Subject: Planning Application 3/2013/0569

Re: 3/2013/0569 Lloyds TSB Berry Lane Longridge, Illuminated signs, please find below Longridge Town Councils comments on this application.

## SIGN ELEVATIONS

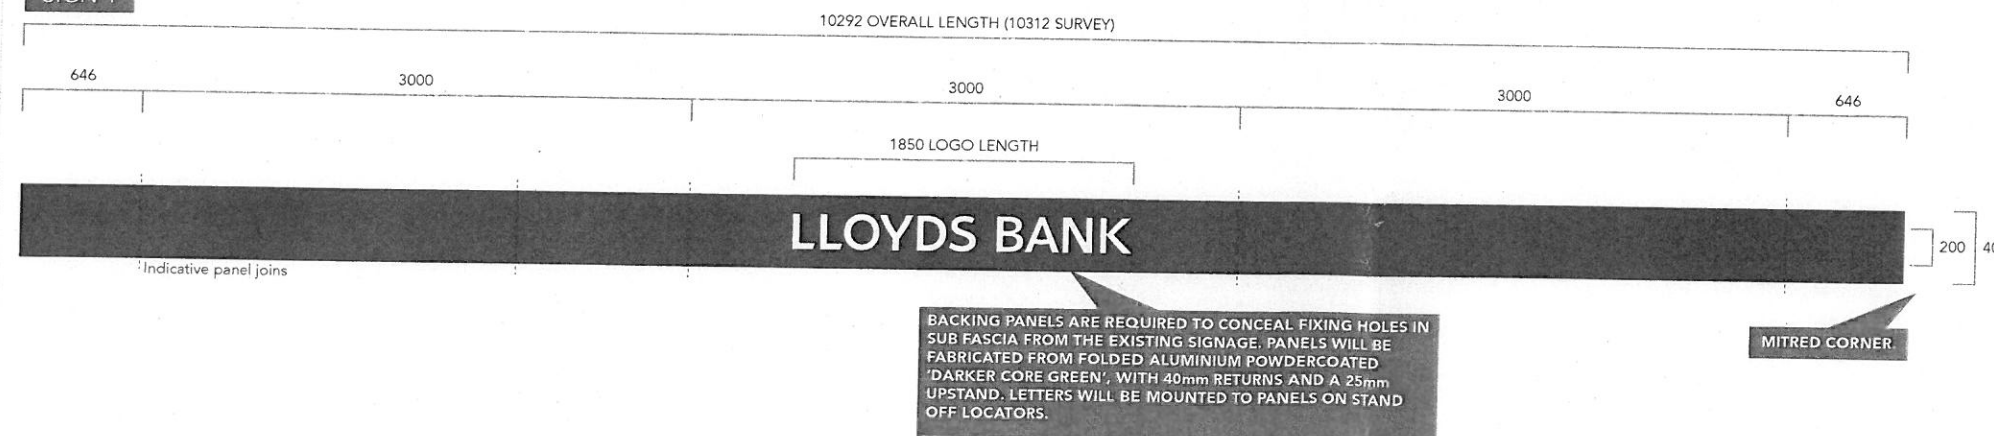
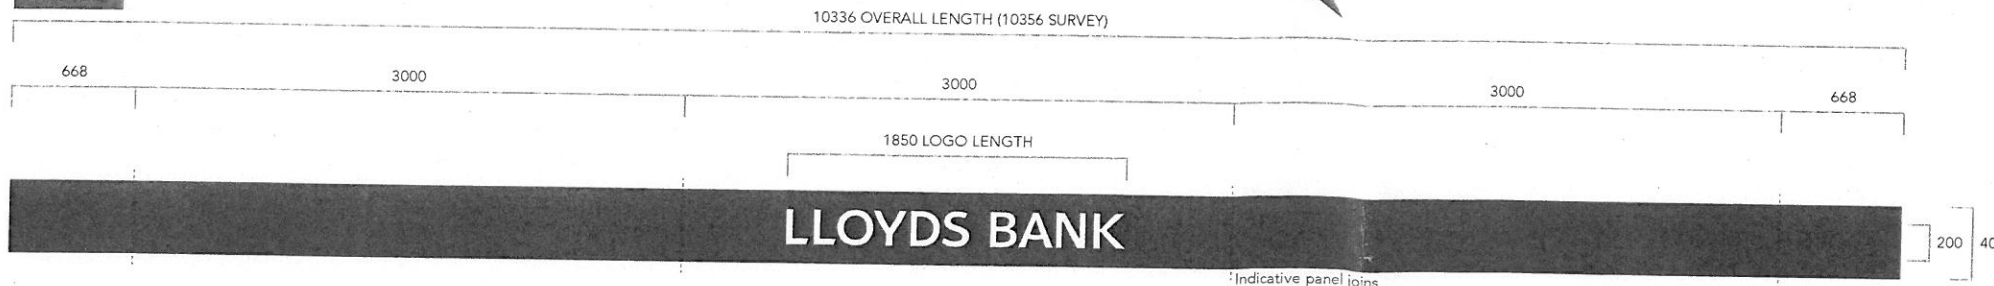
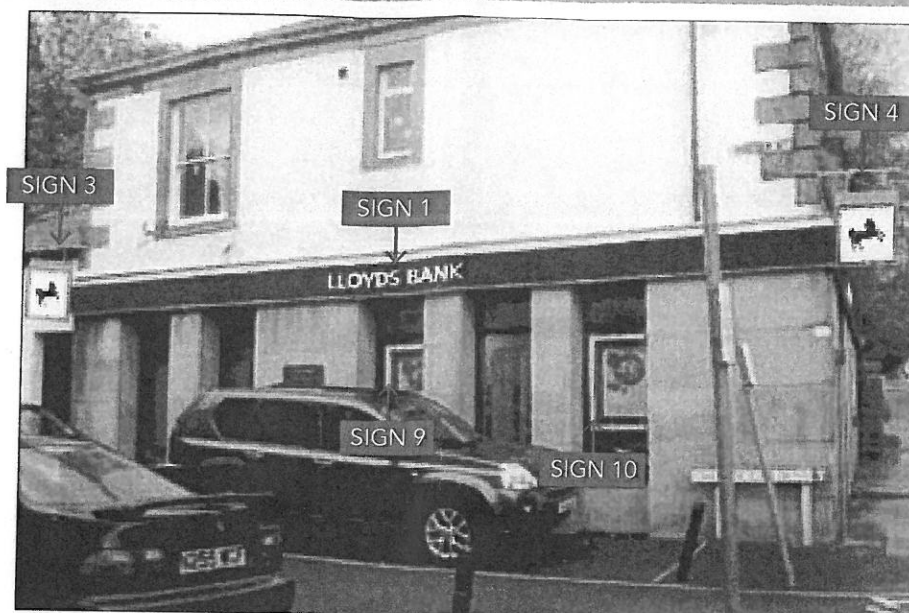
We object and find the planning application ambiguous as it does not state whether the signs are internally or externally illuminated. This property is in a conservation area and as such should conform to RVBC signs policy.
